East Anglia One North (EA1N) and East Anglia Two (EA2) Offshore Wind Farms

Planning Inspectorate Reference: EA1N – EN010077, EA2 – EN010078

Deadline 5 – 3 February 2021

**Comments of Suffolk County Council as Archaeological Authority**

m

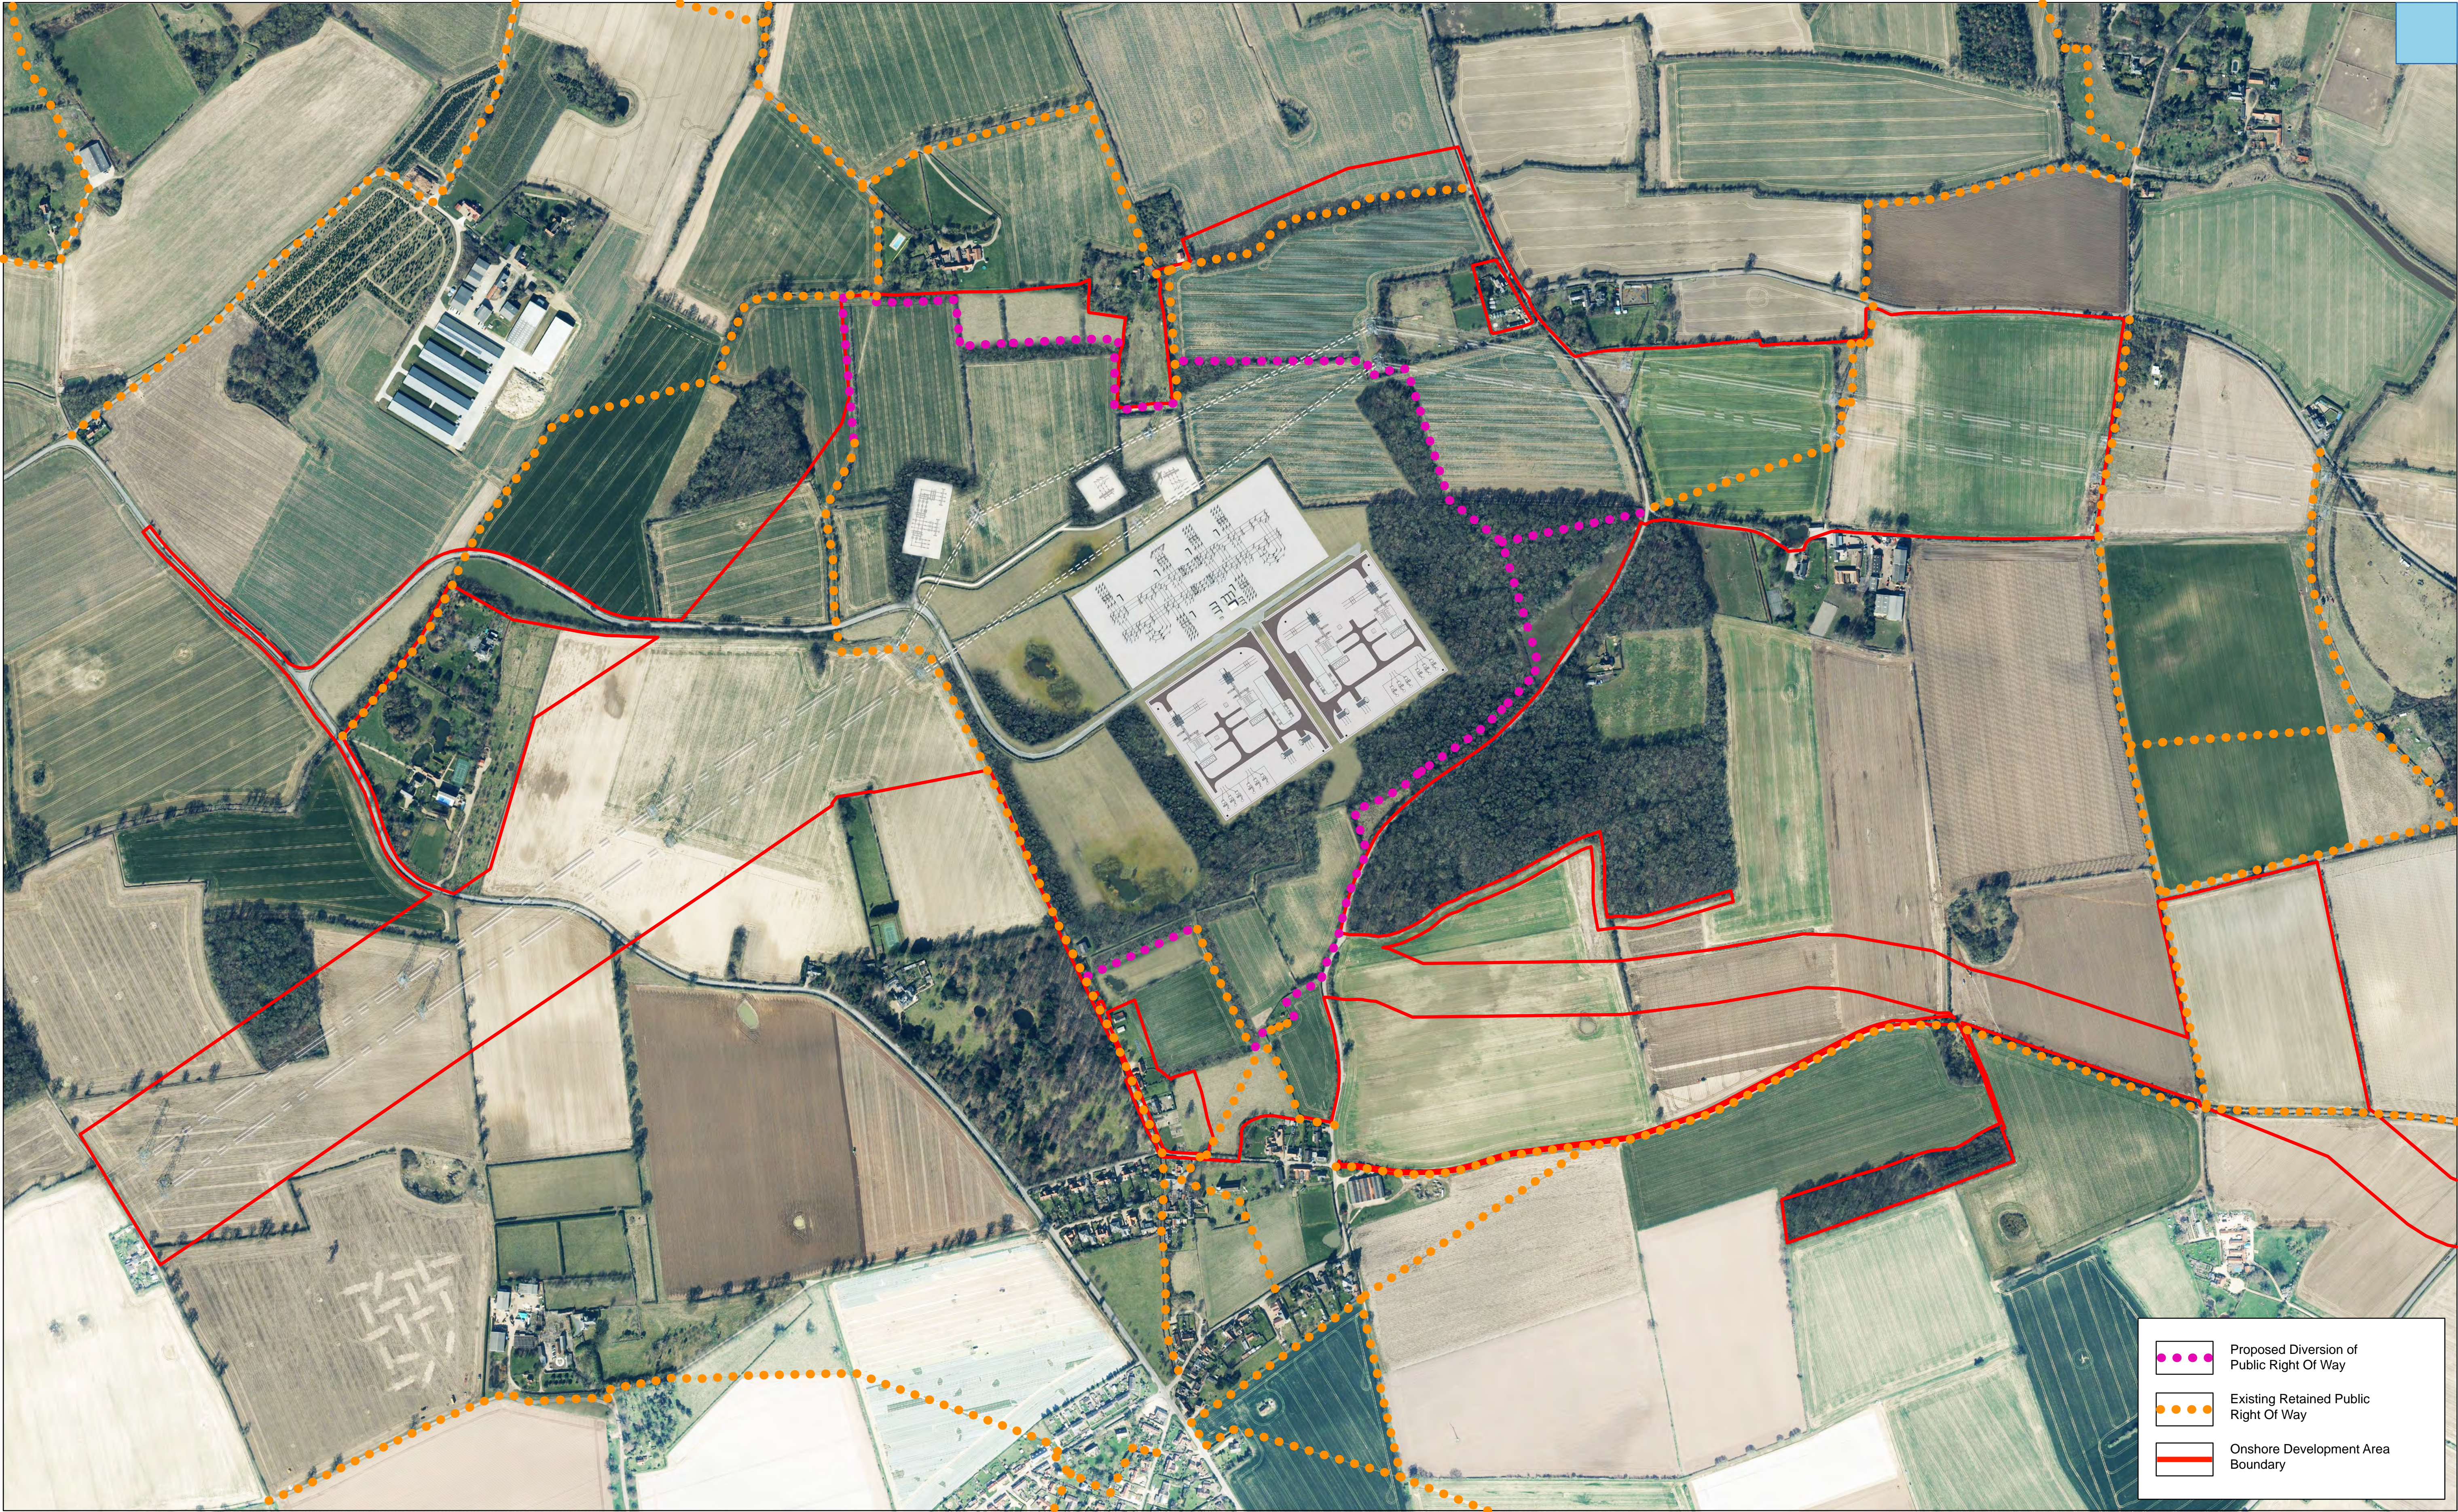
SCC would highlight that archaeological mitigation should be undertaken prior to any agreed landscape mitigation works, including any tree planting areas.
